From:
Sent: 25 May 2026 10:20
To: DC Admin
Cc: Louise Bearcroft
Subject: Re planning application 2025/92713

id 1139684 14/5/26, proposed site/block layout. The drawing in question is Rev J - the 8th amendment.

id 1139685, 14/5/26, proposed landscaping layout. Rev B

PROPOSED SITE PLAN 1:200 @ A1

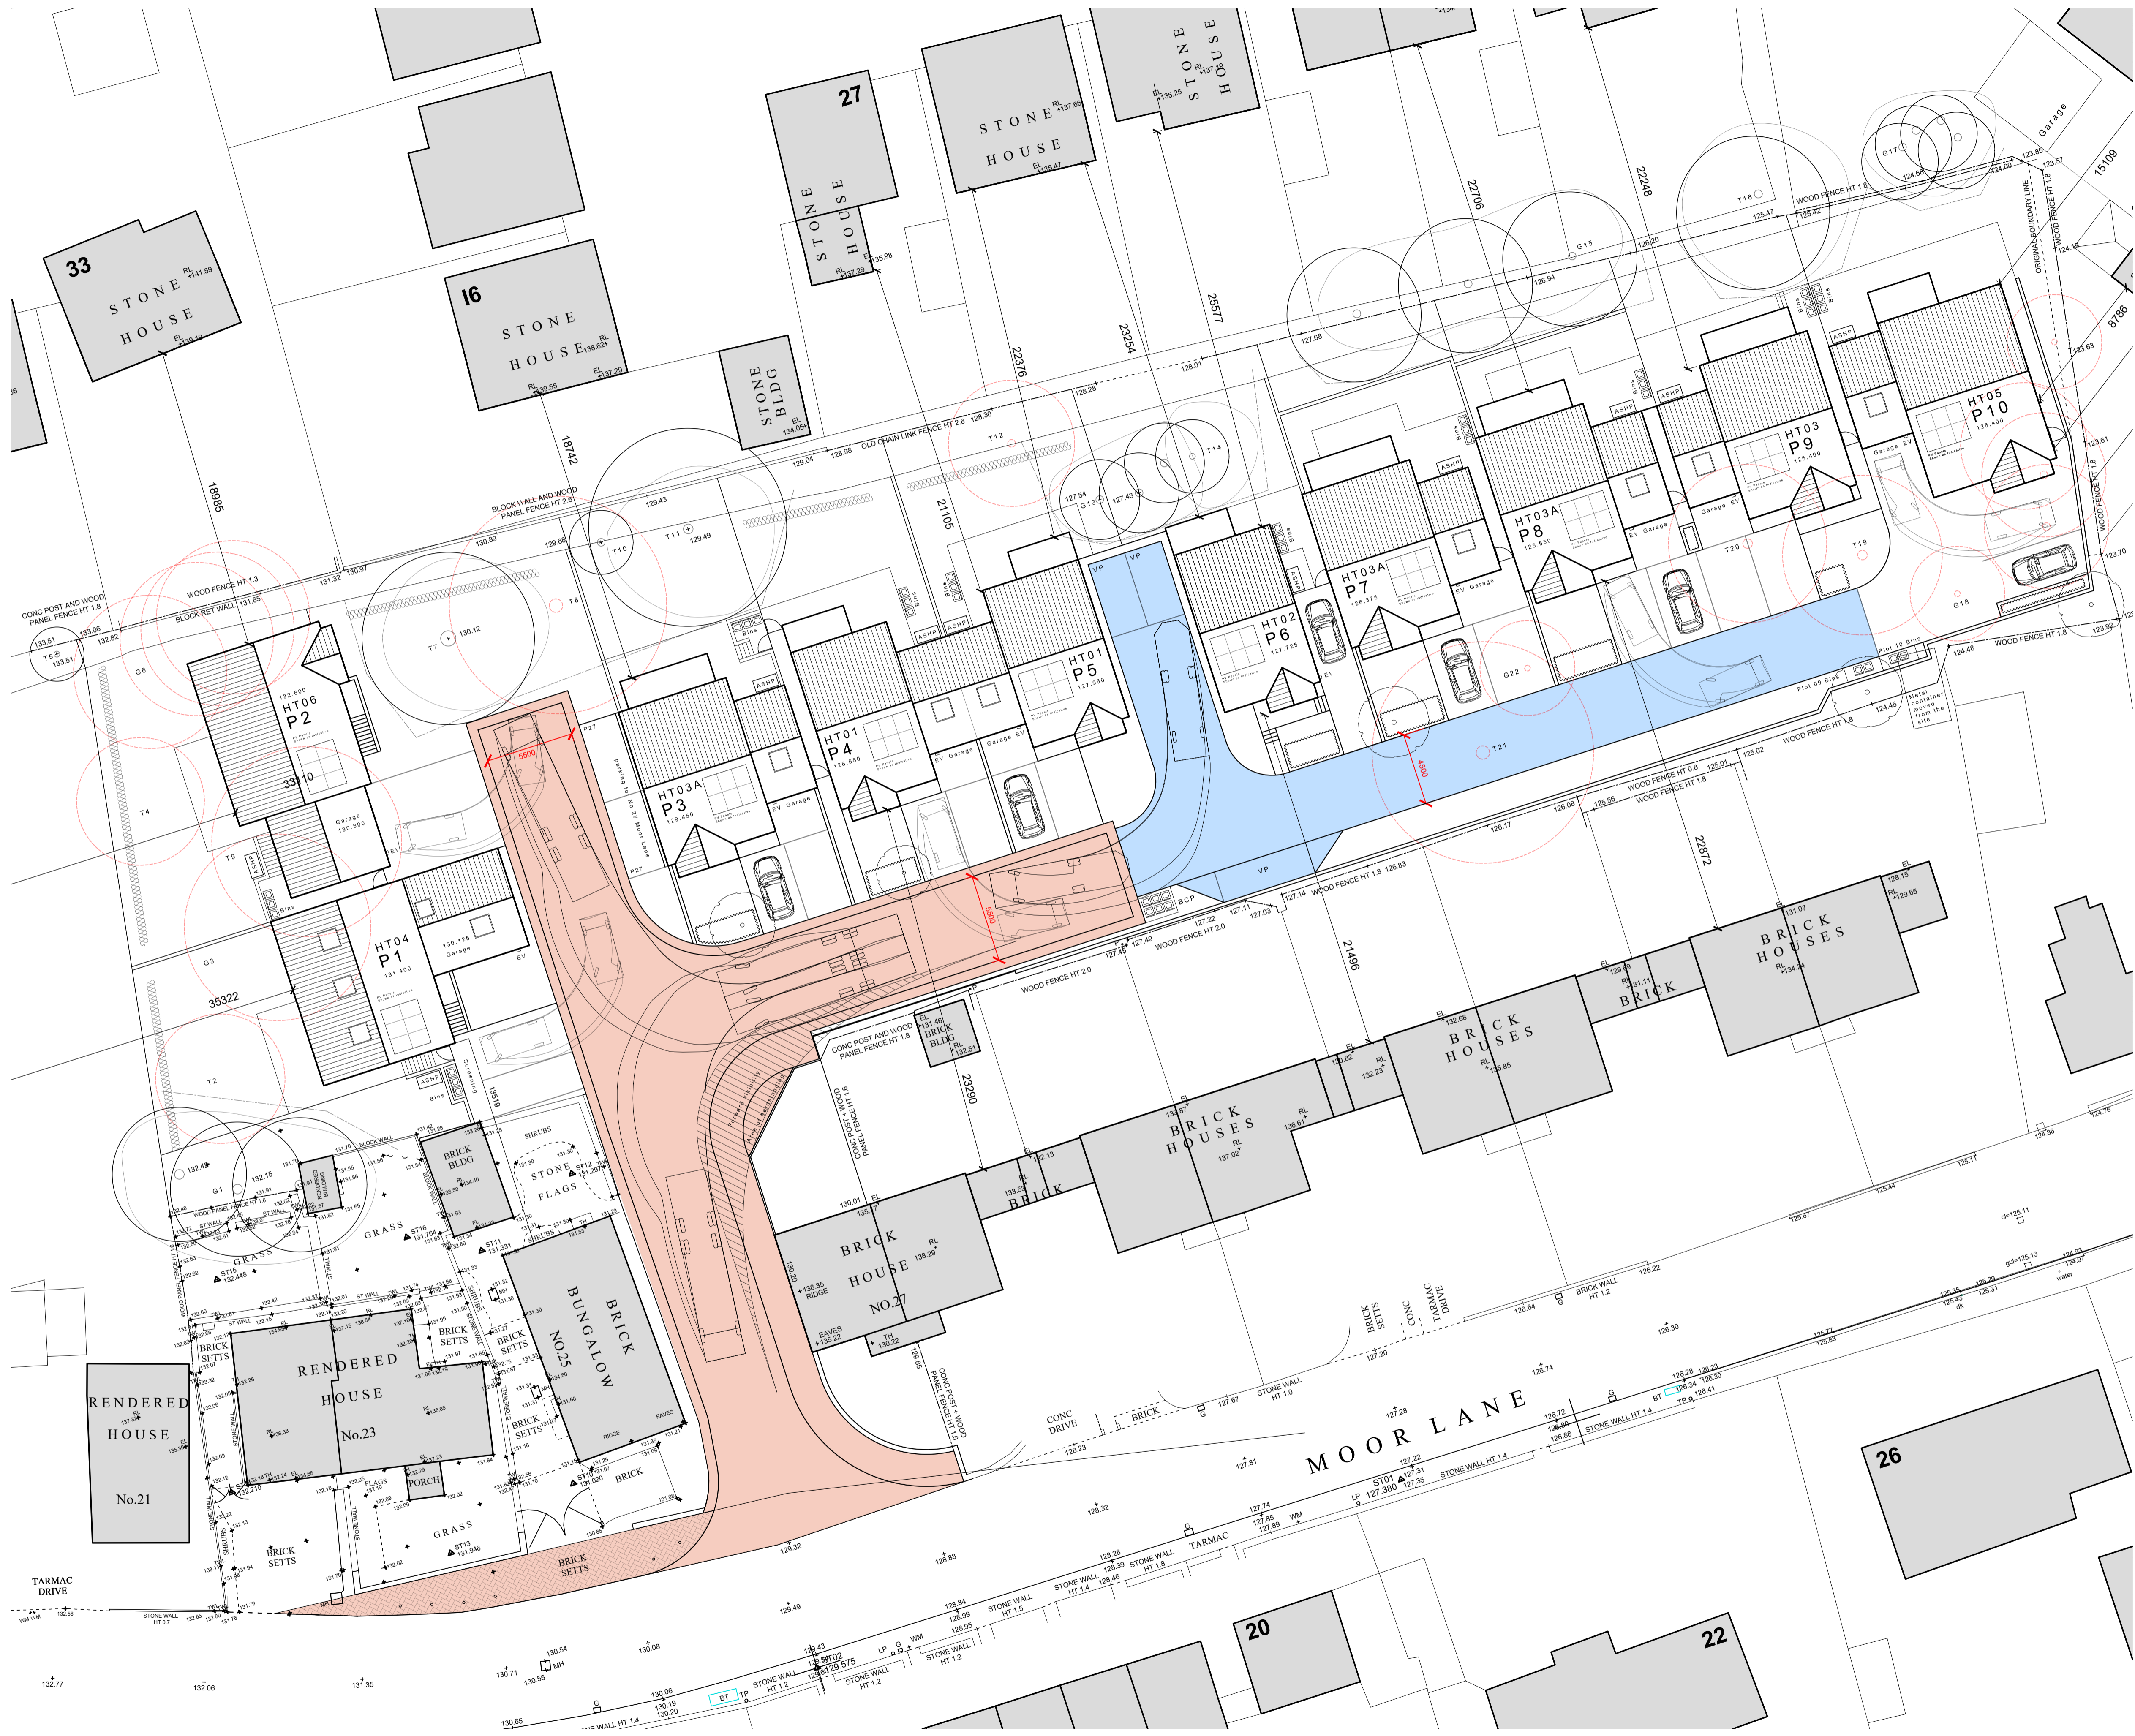
This shows a bin collection point (BCP) for plots 6 to 10. It is now the site entrance side of the turn around adjacent to “the adopted highway”. This change only addresses the bin drag maximum distance for a bin man @ 8 metres but makes the bin drag distances for householders from plots 6 to 10 much worse.

Having a BCP here further comprises the turning space which now has 2 visitor parking spaces at the head and 1 adjacent to the BCP.

The maximum bin drag distances for residents is 25 metres.

The drag distance for plot 8 was previously shown on drawing id 1137136, 30/4/26 (now in superseded) as 30m. The distance on plan id 1139684 is now even longer.

Conveniently, there are no measurements on this new drawing but it does look as though plots 9 and 10 don’t conform either.

The bins for plots 9 and 10 are shown out in the street although they are also shown on the plan as in the back gardens which is confusing!

Bins must not be dragged past parked vehicles - oh dear. The new BCP is the far side of a visitor parking space.

The only way for plot 3 to get their bins out still seems to be down plot 4’s land.

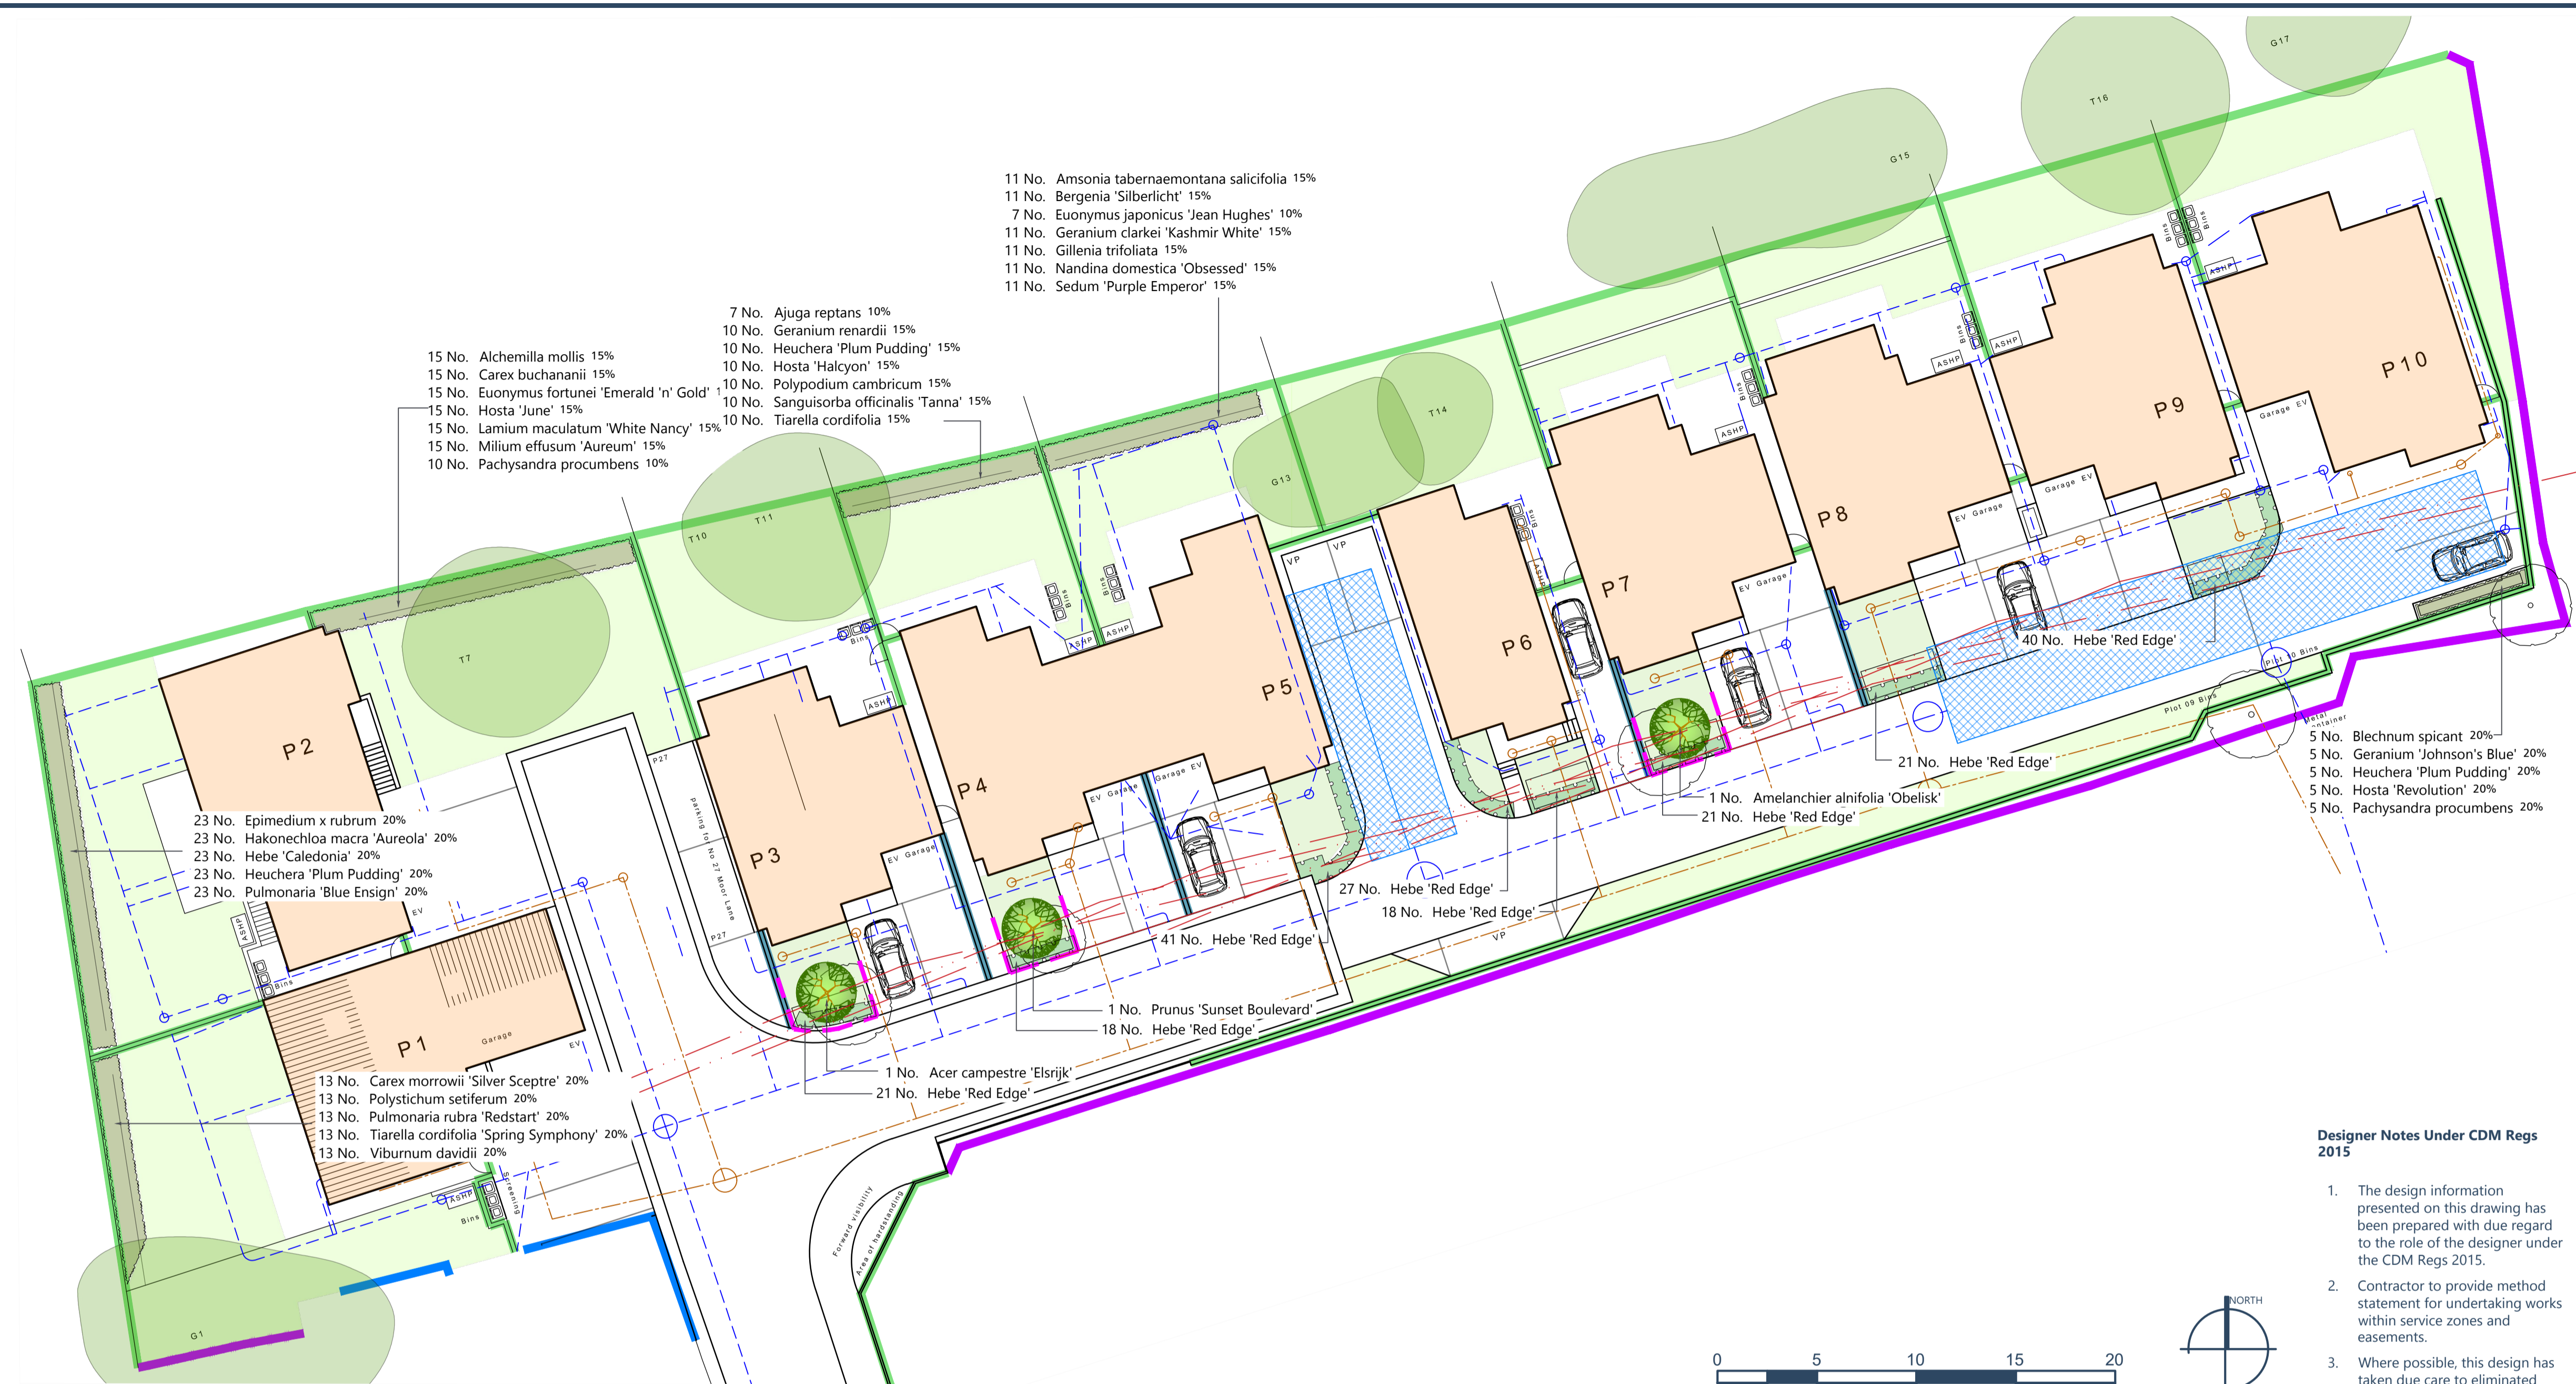
It is hard to distinguish between the 2 greens on this plan denoting grass seeding and amenity space of which there seems to be very little. The gardens seem small and car parking space is lacking. The result is a cramped, contrived development.
